From: Grant, David
Sent: 24 June 2021 15:15
To: _planningadvice
Subject: FW: Rosecott Farm H14-0602-21
Attachments: We sent you safe versions of your files; e2c0cbc4-4b4c-4dfa-ab98-1b42bf3d1285.JPG; 2dd85ec4-b5b7-4ec3-aa5f-929cc4e83d36.JPG; 3626-20-02A(LUNNS).pdf; S25C-0i21062413580.pdf

Subject: Re: Rosecott Farm H14-0602-21

FULL DESCRIPTION OF DEVELOPMENT OF CURRENT APPLICATION THAT THIS AMENDMENT RELATES TO	Change of use from Paddock area to haulage yard & storage including lighting.	
State details of amendments proposed. (Give a full detailed list of the changes, and also mark these clearly on the accompanying plans. Only the changes listed here will be considered)	Additional notes	
State drawing numbers of the current submission	02A	
Has this amendment been requested by the Council? (If so, state Officer dealing with the application)	YES/NO	D. Grant
Describe any part of the original development which is excluded by virtue of the amendment, and state any alteration to plot numbers	/	
Has a similar amendment been submitted under Building Regulations? (If so, state Building Control Surveyor dealing with application)	YES/NO

Drawing
SITE & LOCATION PLANS.

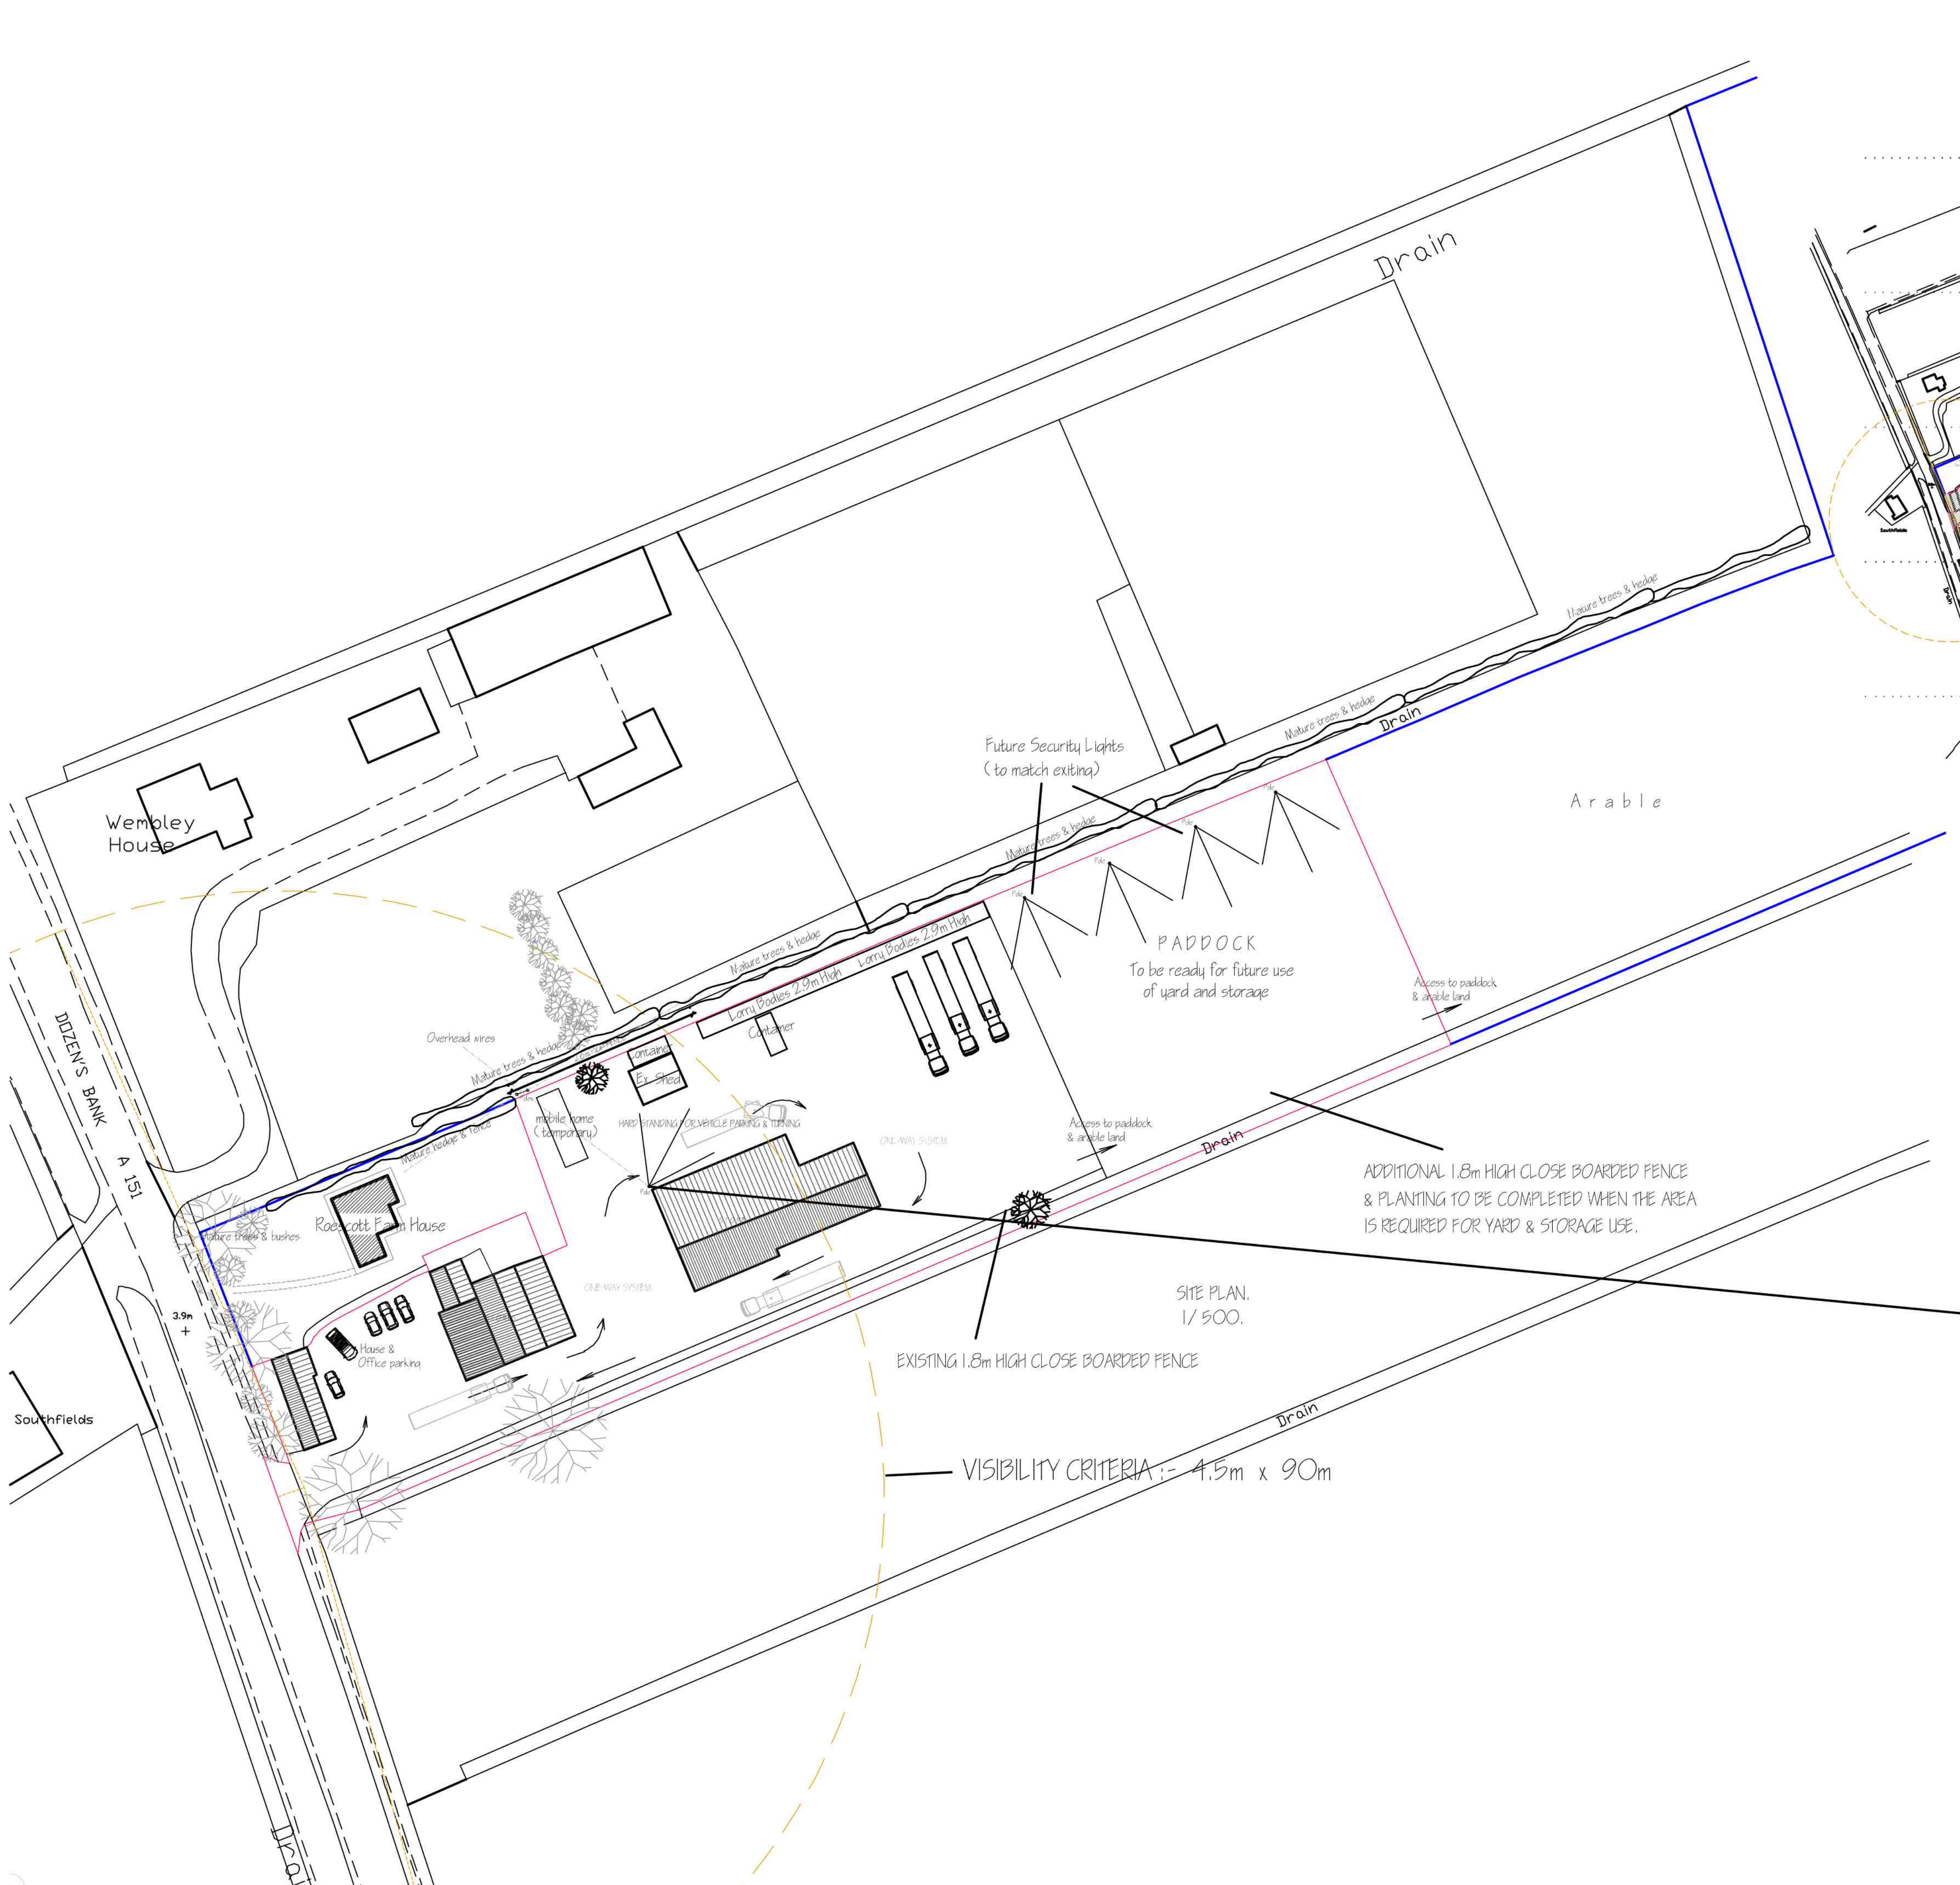
- Traffic and parking... how will this be arranged in the paddock?
-
- Appearance of the area could you please advise as to where the proposed containers will be positioned, ie will we see the sides/back and not the front opening where the vans etc will be loading?
- what colour will said containers be?
- and how many?
-
- Noise and disturbance.... we do live on **what** is now a very fast, busy road so we understand that noise will not change, but what hours will the paddock land containers be open to the renters for access and loading?
- Privacy..... will the lighting be directed down only on the containers and towards the owners property?
- Will boundary fencing/planting be added to stop the viewing of containers?

1. Traffic and parking - at present all traffic and parking is mainly to the left of the site there is strict 1 way system and vehicles leaving the site use the right hand roadway and additional containers in the yard and the future paddock area will be kept to the left of the site allowing for access to be left to the right of the paddock and arable land.

2. Appearance of the area - again the containers will be mainly on the left of the site and these containers will be painted green as per the already existing ones. At present the applicant only has 2 No containers on site. The existing yard area is capable of taking a fw more however, the change of use of the paddock area to extra yard will likely be not requirement for a couple of years to is is hard to dterine number of containers on site at peasant as it will be down to need at that time.

4. privacy - When the lighting is installed the lighting will be directed down to the containers only as this is a health and safety requirement of the site. My client is currently fencing the Southern boundary to the existing yard area he is more than happy as the site progresses that extra fencing/planting will be carried out along the southern boundary to make sure the site has less impact on any neighbours.

We attach an amended plan showing where the existing fencing goes down to and a note saying the client will extend the fencing and planting if/when required.
